# KITTITAS COUNTY

**TO:** All Staff  
**FROM:** Public Works Plan Review Team  
**DATE:** November 16<sup>th</sup>, 2023  
**SUBJECT:** SP-23-00007 Nelson View

KITITITAS COUNTY		WASHINGTON	
DWN BY	DATE	JOB NO.	
D.L.P./G.W.	9/15/23	230162	
CHKD BY	SCALE	SHEET	
D.L.P./D.B.M.	1"=200'	2 OF 2

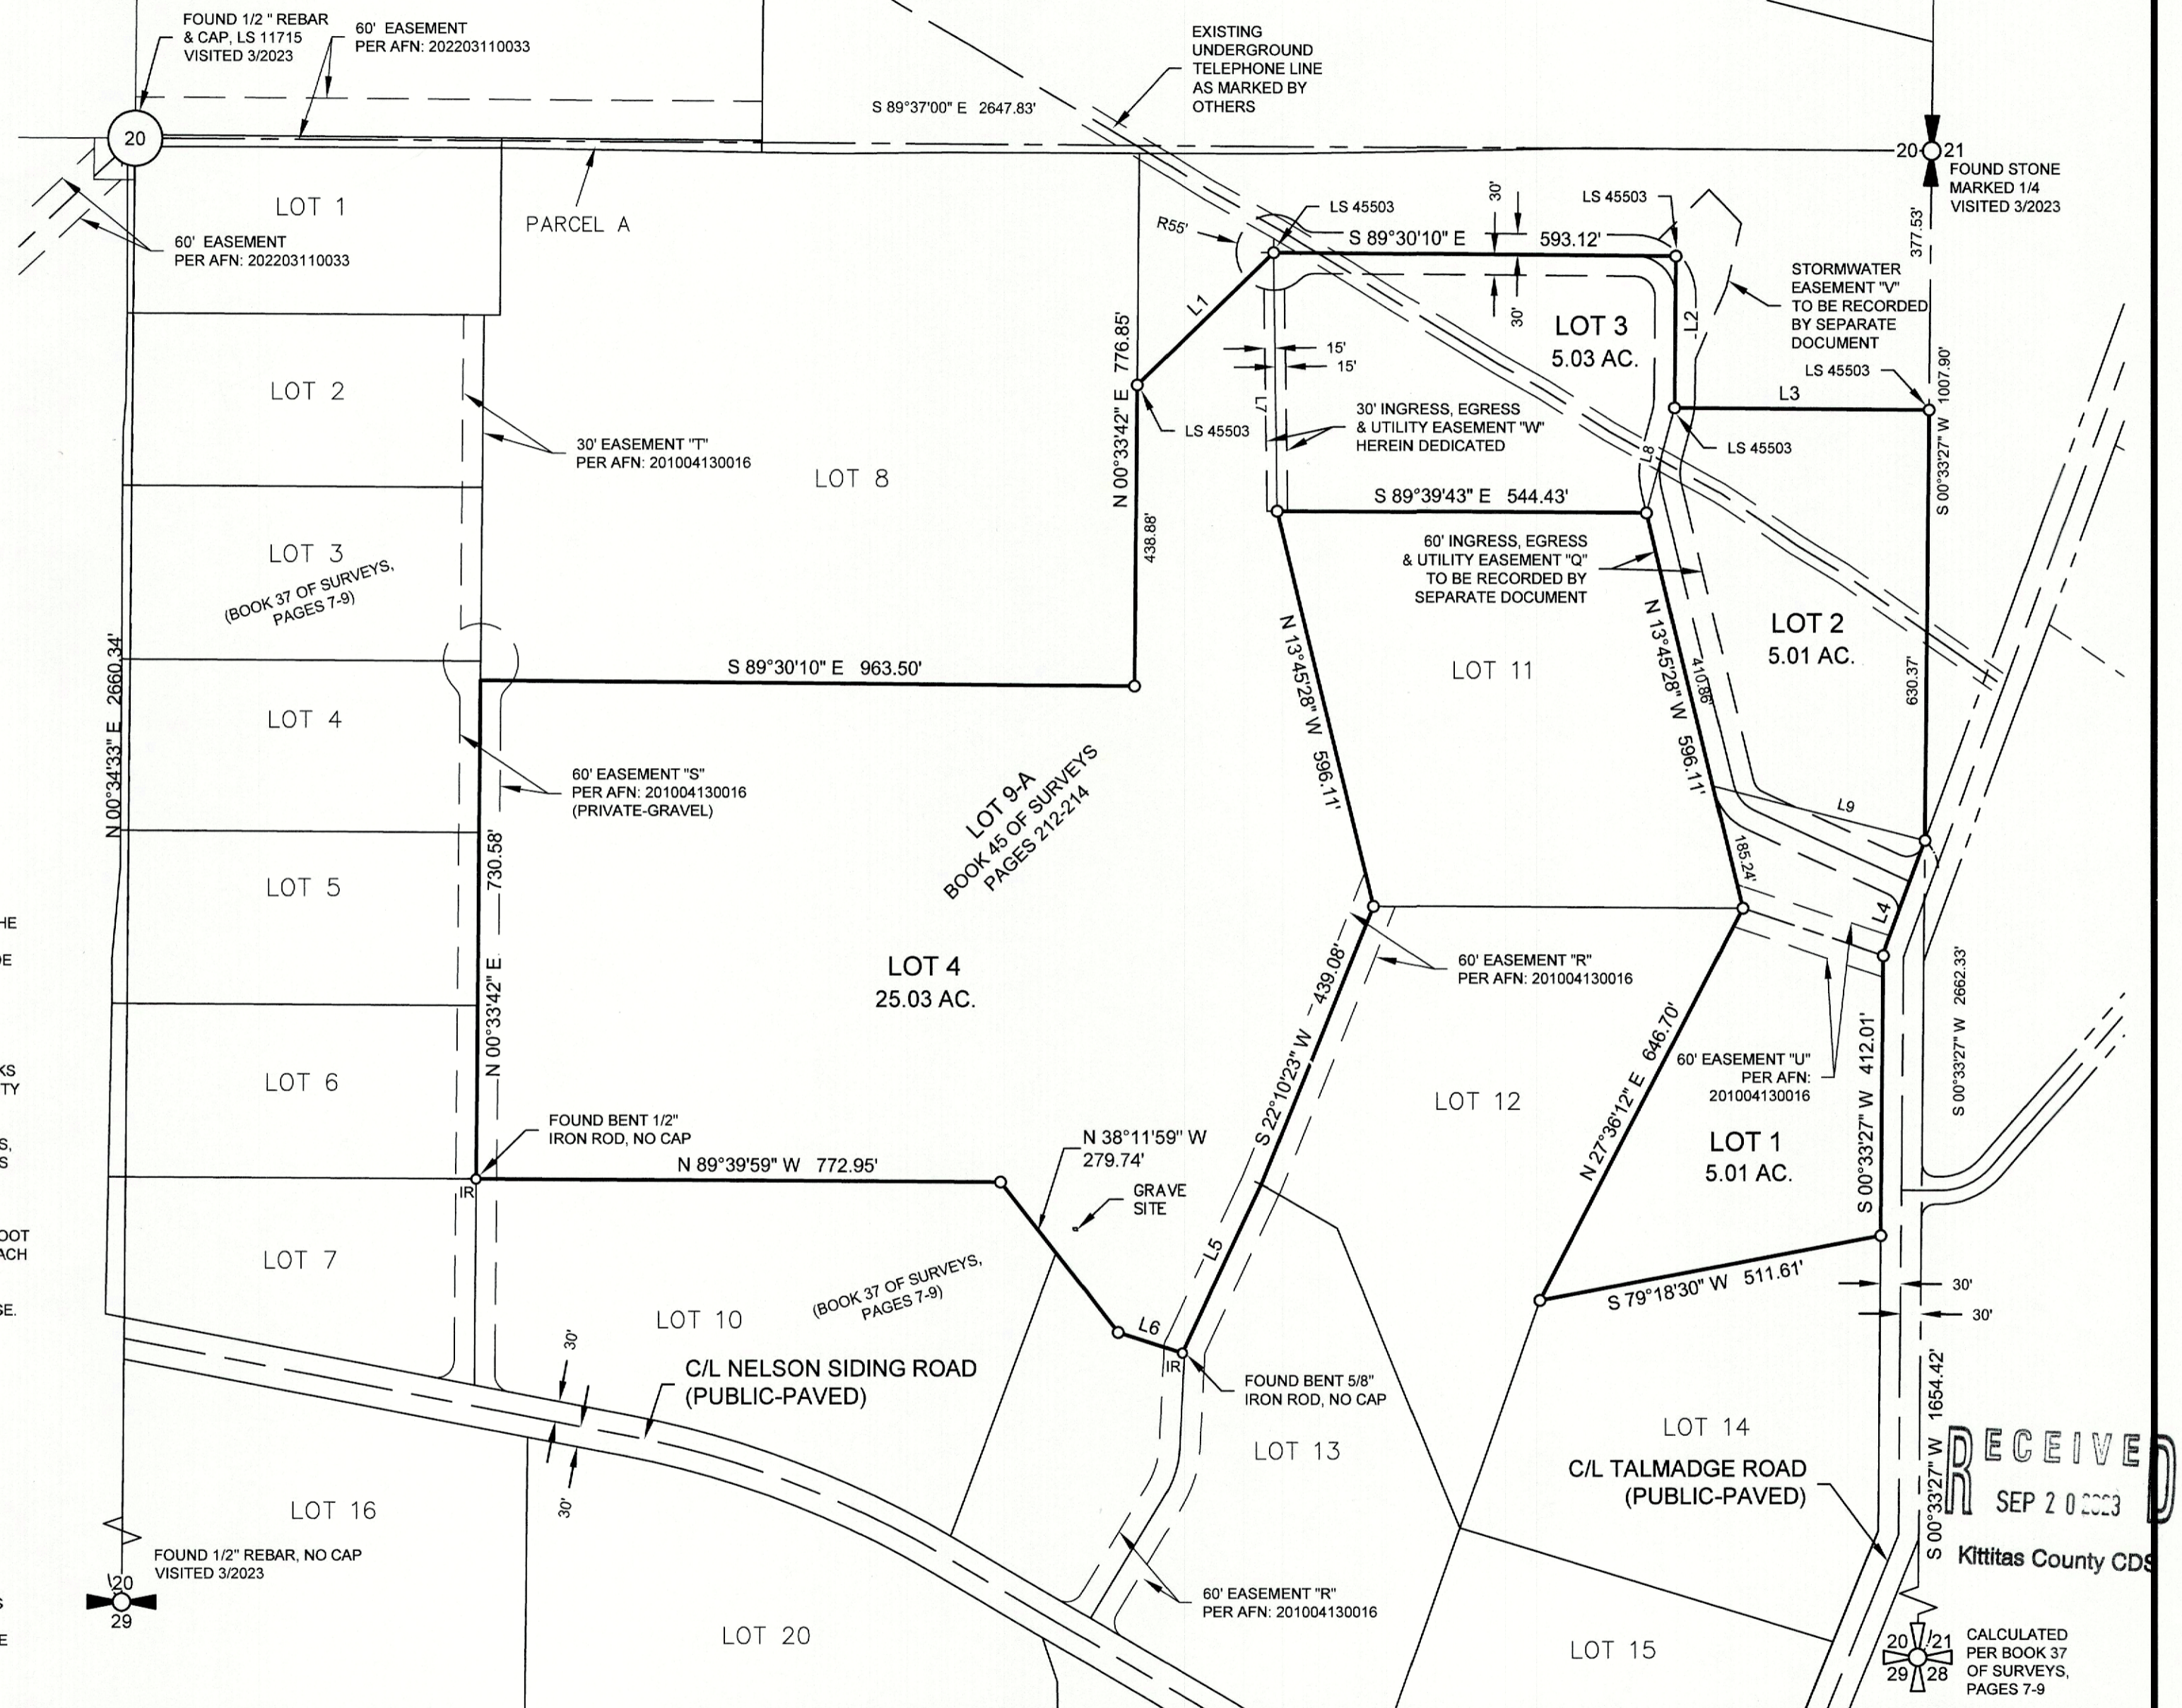
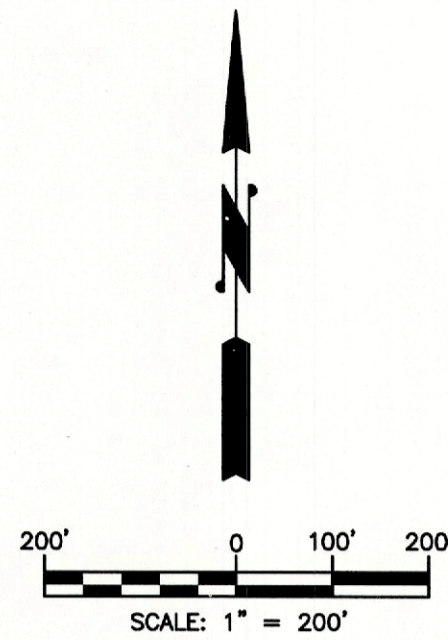
<b>SURVEY</b>	<p>Regarding the Preliminary Plat:</p> <p>1. The Preliminary Plat does not meet the requirements of WAC: 332-130-145 in regards to topographic elements.</p> <p>The following will need to be addressed prior to Final Short Plat approval:</p> <ol style="list-style-type: none"> <li>1. Per Note 5, Sheet 1, access to Lot 1A is via a private easement. No Lot 1A shown on the face of this Short Plat. If this note is to remain, Lot 1A shall be shown as well as Pioneer Trail Road shall be labelled.</li> <li>2. Notes 6, 8 and 9 all reference different basis of bearings statements, and make references to Lots not shown on the face of the Short Plat. Please resolve, and if multiple Basis of Bearing were utilized, please include the rotation and direction (clockwise or counterclockwise), that was used to put it in the final rotation shown on the map.</li> </ol> <p>Of Note (changes not required)</p> <p>As the proposed access easement is not mathematically retraceable, please ensure the separate document includes and mathematically retraceable description, and does not simply reference the Short Plat.</p>
